Appeal Decision

Appeal Ref: 6001903

33 Hoyle Mill Road, Stairfoot, Barnsley S70 3EN

- The appeal is made under section 78 of the Town and Country Planning Act 1990 (as amended) against a refusal to grant planning permission.
 - The appeal is made by Estelle Avia against the decision of Barnsley Metropolitan Borough Council.
 - The application Ref is 2025/0750.
 - The development proposed is subdivision of existing dwellinghouse to create 2x 1-bedroom flats.
-

PROPOSED GROUND  
 FLOOR PLAN

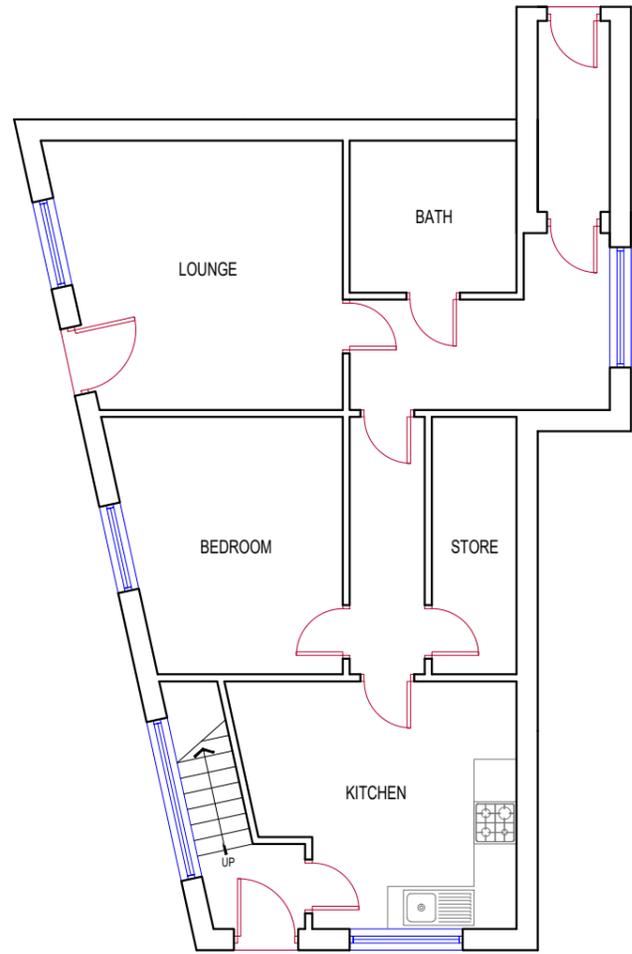
11. Policy GD1 of the LP require development to have no significant adverse effect on the living conditions of residents. The South Yorkshire Residential Design Guide 2011 (RDG) notes that a one-bedroom unit should provide 46m² of space for a one-person unit. Overall, the proposed subdivision would comply with this specific requirement. However, the RDG further details the room sizes which must be achieved as a minimum. It states that a one-bedroom flat should have a bedroom which is 12m² and a kitchen that is 13m². The proposed ground floor flat would fall short of these minimum standards.

12. It is argued that the shortfalls identified within individual rooms are minor and could be addressed through a revised layout secured by condition, or by imposing a condition requiring full compliance with the RDG minimum space standards. However, the application was submitted in full and must be determined on the basis of the information provided at the time of submission. Compliance with the minimum space standards set out in the RDG is a fundamental consideration that should be demonstrated as part of the proposal itself, rather than deferred to a condition.

DRAWING TITLE:  
 PROPOSED PLANS

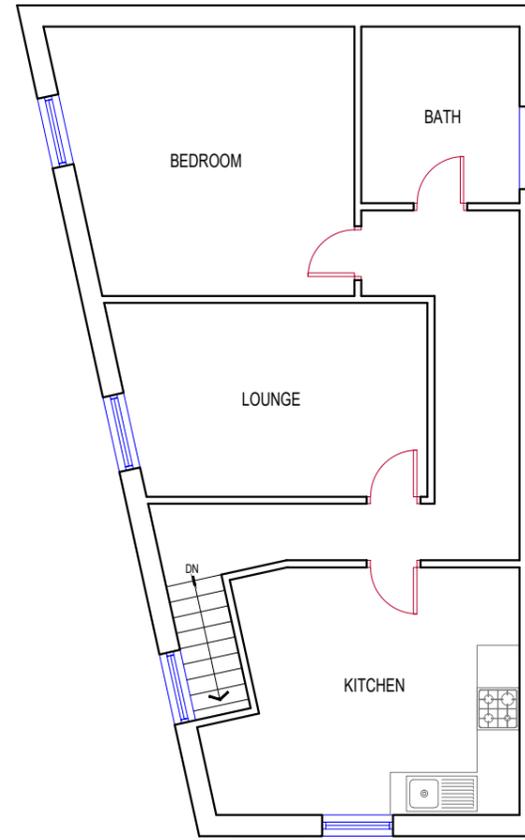
space or added to shared private space. A small area is located to the rear of the property. I cannot ascertain the overall numerical size of this space, however, given its notably confined area, it would not provide the minimum shared area of space and the additional 10m² as required by the SPD. It would not offer any private space for any of the individual units. In this configuration, occupiers will not be able to utilise a private space for their own personal outdoor relaxation or to undertake recreational activities away from the other resident. As such, the development fails to meet the standards set out in the SPD.

15. It is further submitted that the appellant would be willing to accept a condition requiring the clear delineation and management of the shared amenity space. However, given the extremely limited size of the existing amenity area, I am not persuaded that it could be delineated or managed in a manner that would meet the requirements of the SPD. The constraints of the site are such that an acceptable arrangement could not realistically be achieved through the imposition of a condition.
